## Rosefield Solar Farm DCO Examination

### Preston Farms Ltd and TCS Biosciences Ltd (PFL/TCS)

#### Submission and evidence following ISH1-2 to inform and assist the Examining Authority – for Deadline 3

Chapter 4: Alternatives and Design Evolution

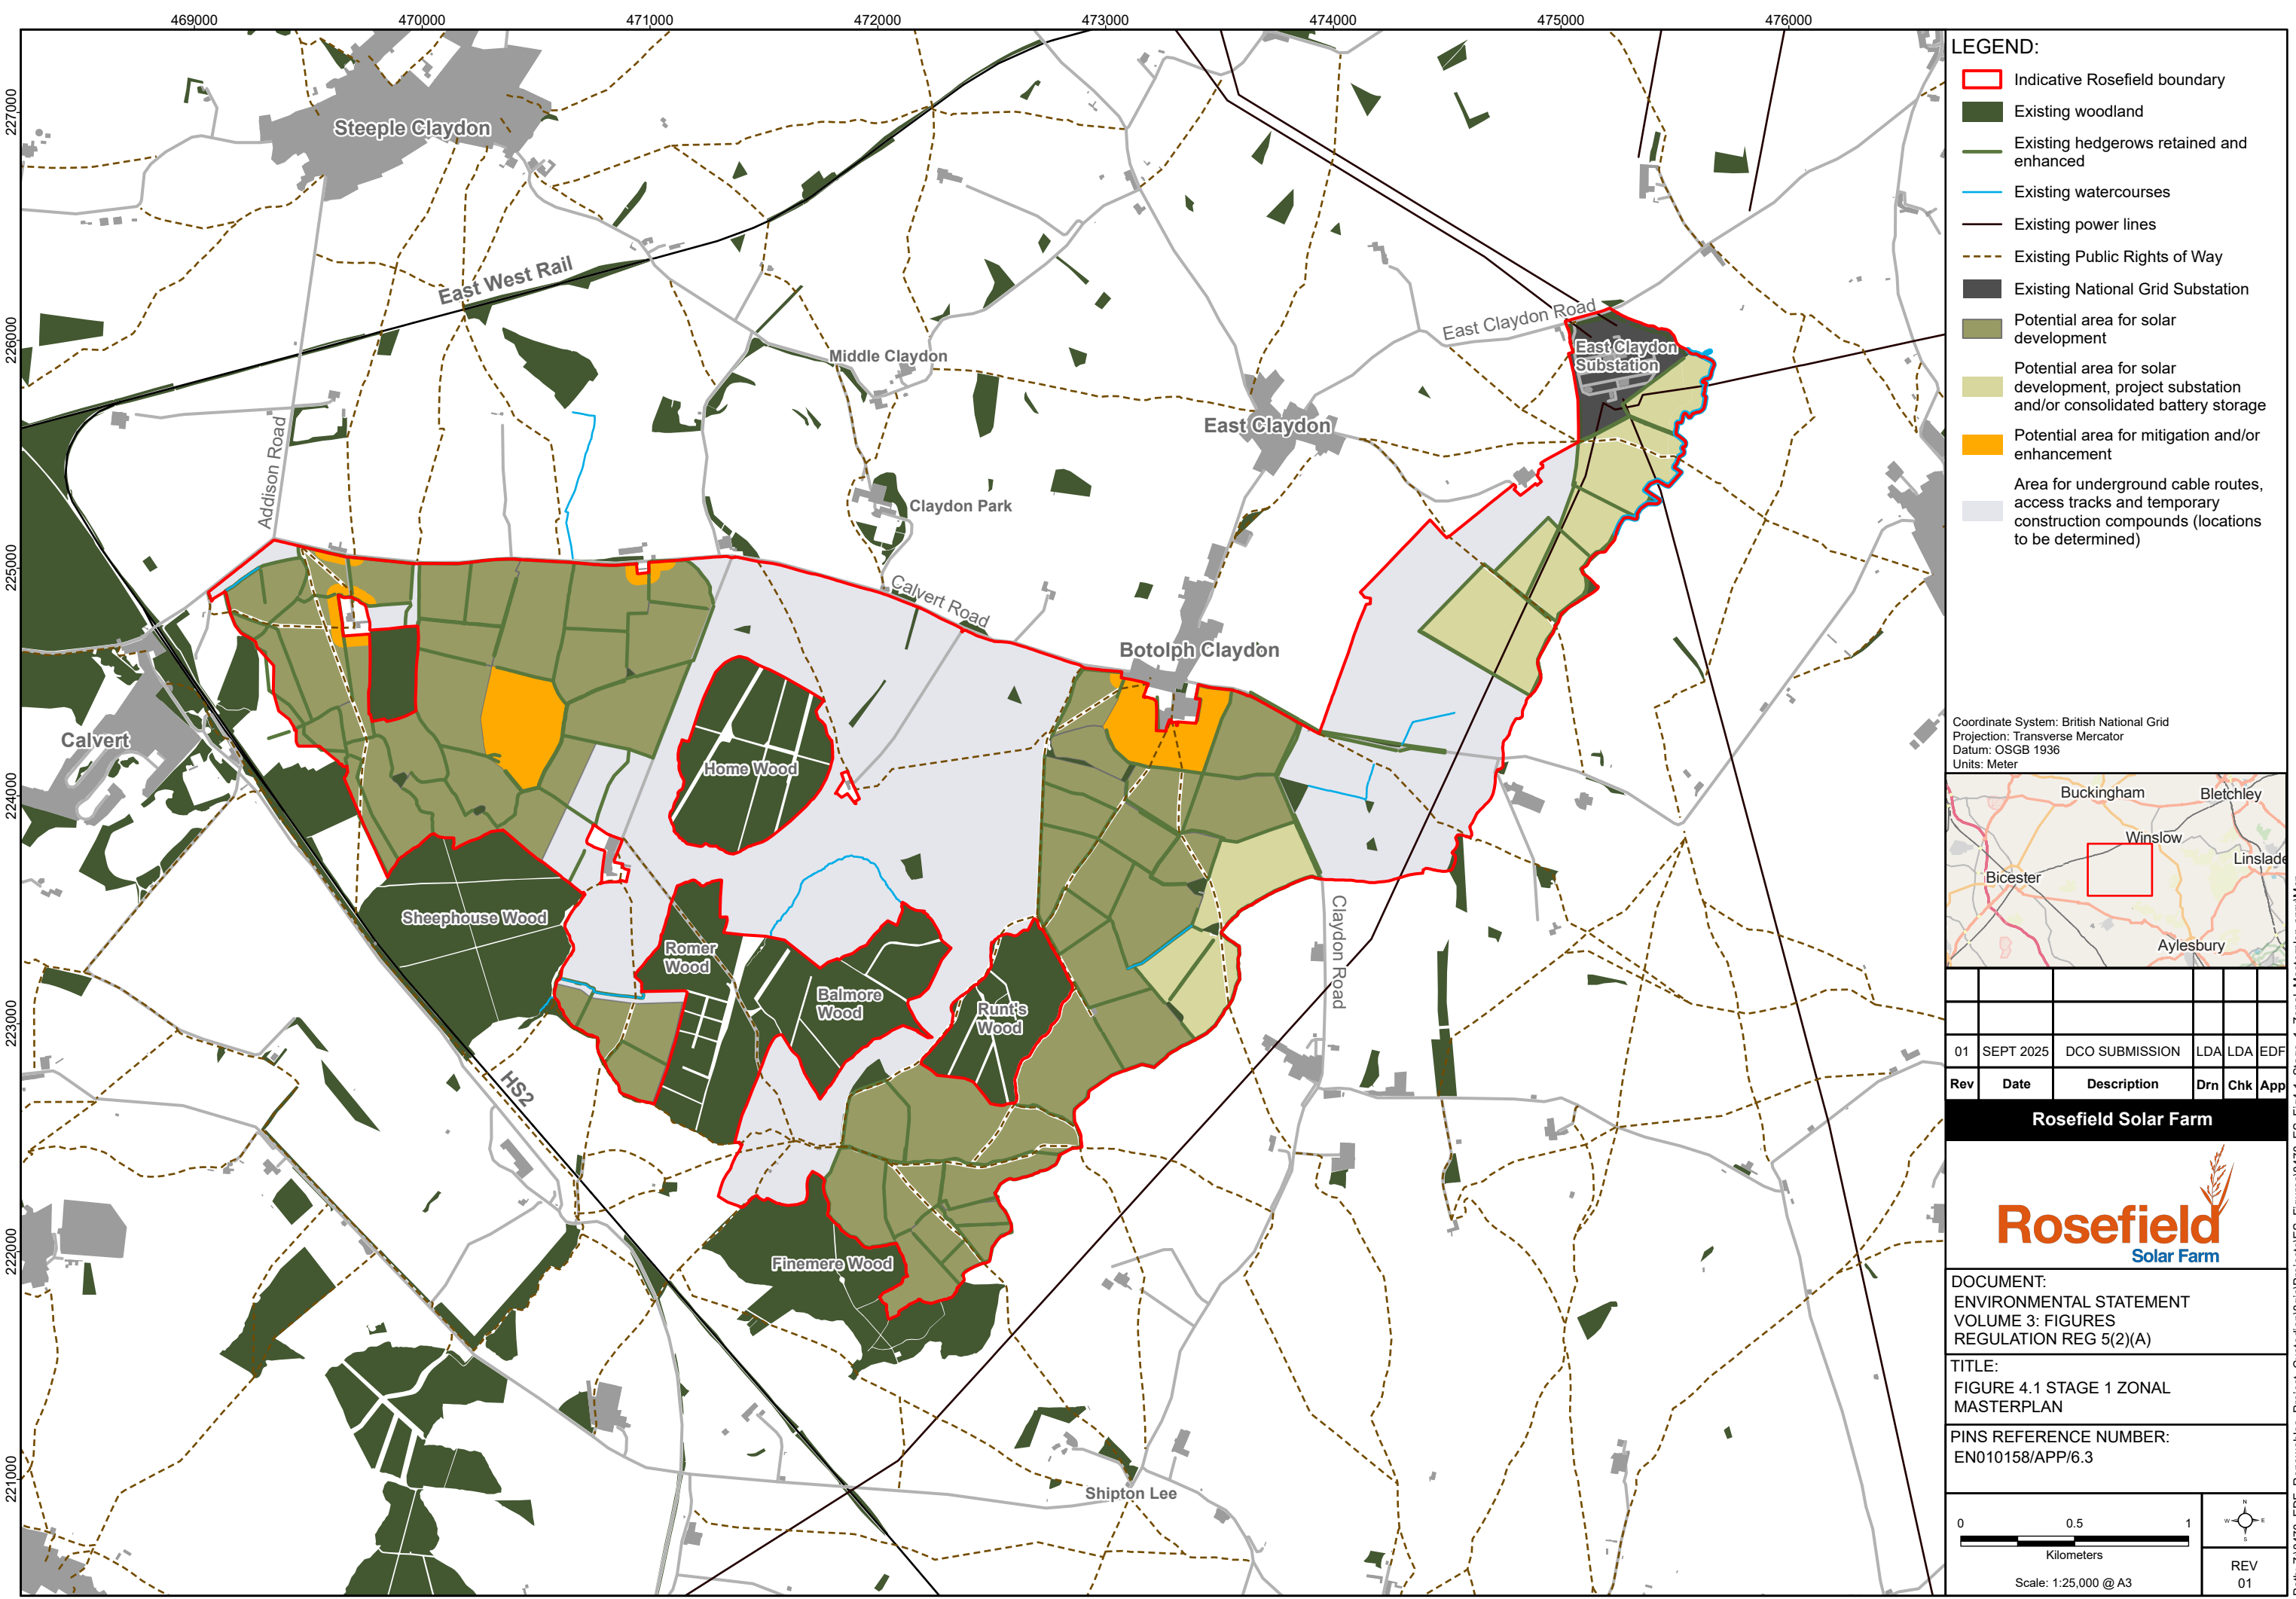
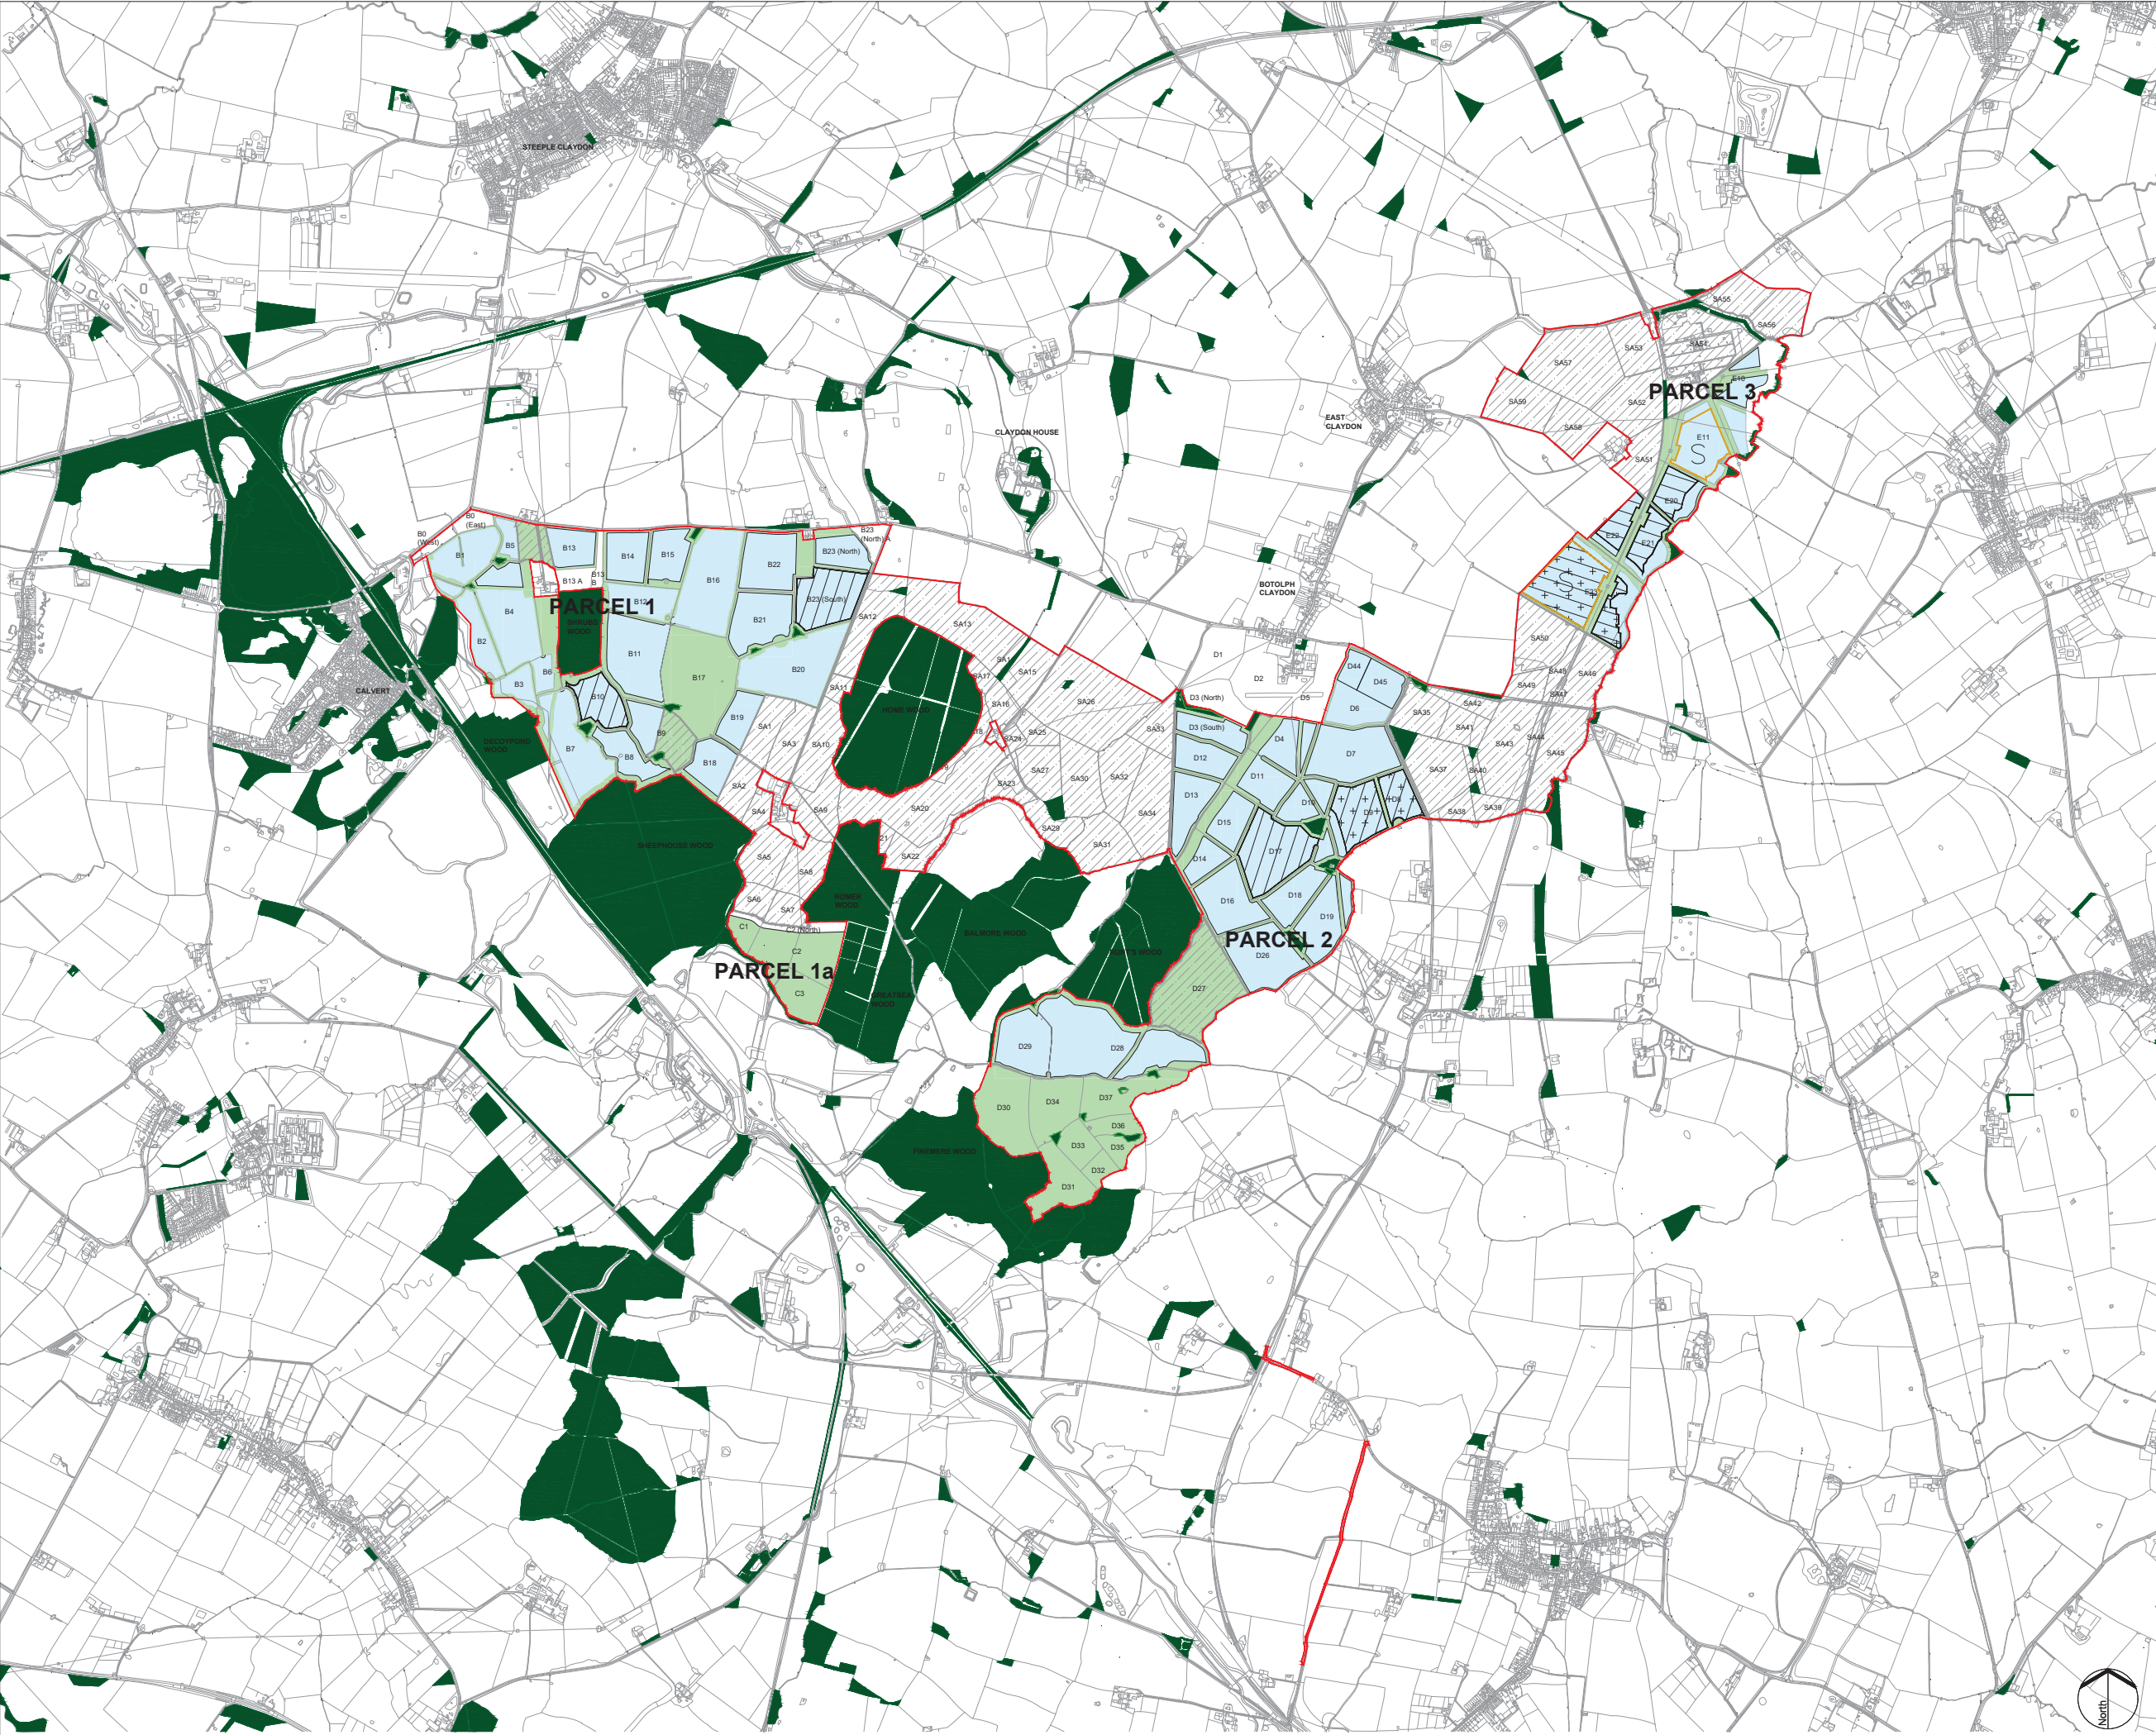
4. Over the lifetime of this project, the Proposals have encroached significantly further into our holding. The Applicant's attempts to assert otherwise are not credible. We know what we were told when we were first approached about the proposals in 2022, and it is shown clearly on the 'site layout' plans in the ES Wintering Birds and Bat Surveys,<sup>1</sup> which stand in contrast to the airbrushing of this part of the history elsewhere in the ES. The shift from a smaller Parcel 3 tightly centred on the East Claydon substation, to the present Proposals Parcel 3 that stretches down to take the heart of our Holding, does not 'mitigate' the impact on us, but the opposite.

5. The fact of the first, subsequently airbrushed, option, shows that there is (a) at least one reasonable alternative the Applicant considered but has not presented or explained in the ES for the purposes of the EIA Regulations; (b) at least one alternative to be considered when applying compulsory acquisition principles (see our WR, but in short part of the 'compelling case' is an absence of alternatives);<sup>2</sup> and (c) there is a

<sup>1</sup> **APP-089** pp27-28 (Figures 1 and 2, including 'site location' red line plans), see also **APP-088** pp18, 21 (Figure 1, Figure 2.3, including 'site location' red line plans). Then see **APP-047** (reasonable alternatives considered), in particular section 4.7, for the complete lack of acknowledgement of this within the purported explanation of the design evolution.

<sup>6</sup> See **APP-088** (2022 bat survey) and **APP-089** (2022 wintering birds survey) and in particular their figures which show the originally proposed site red line and demonstrate the limited extent of 'parcel 3' as first explained to us. Then see **APP-047** (reasonable alternatives considered), in particular section 4.7, for the complete lack of acknowledgement of this within the purported explanation of the design evolution.
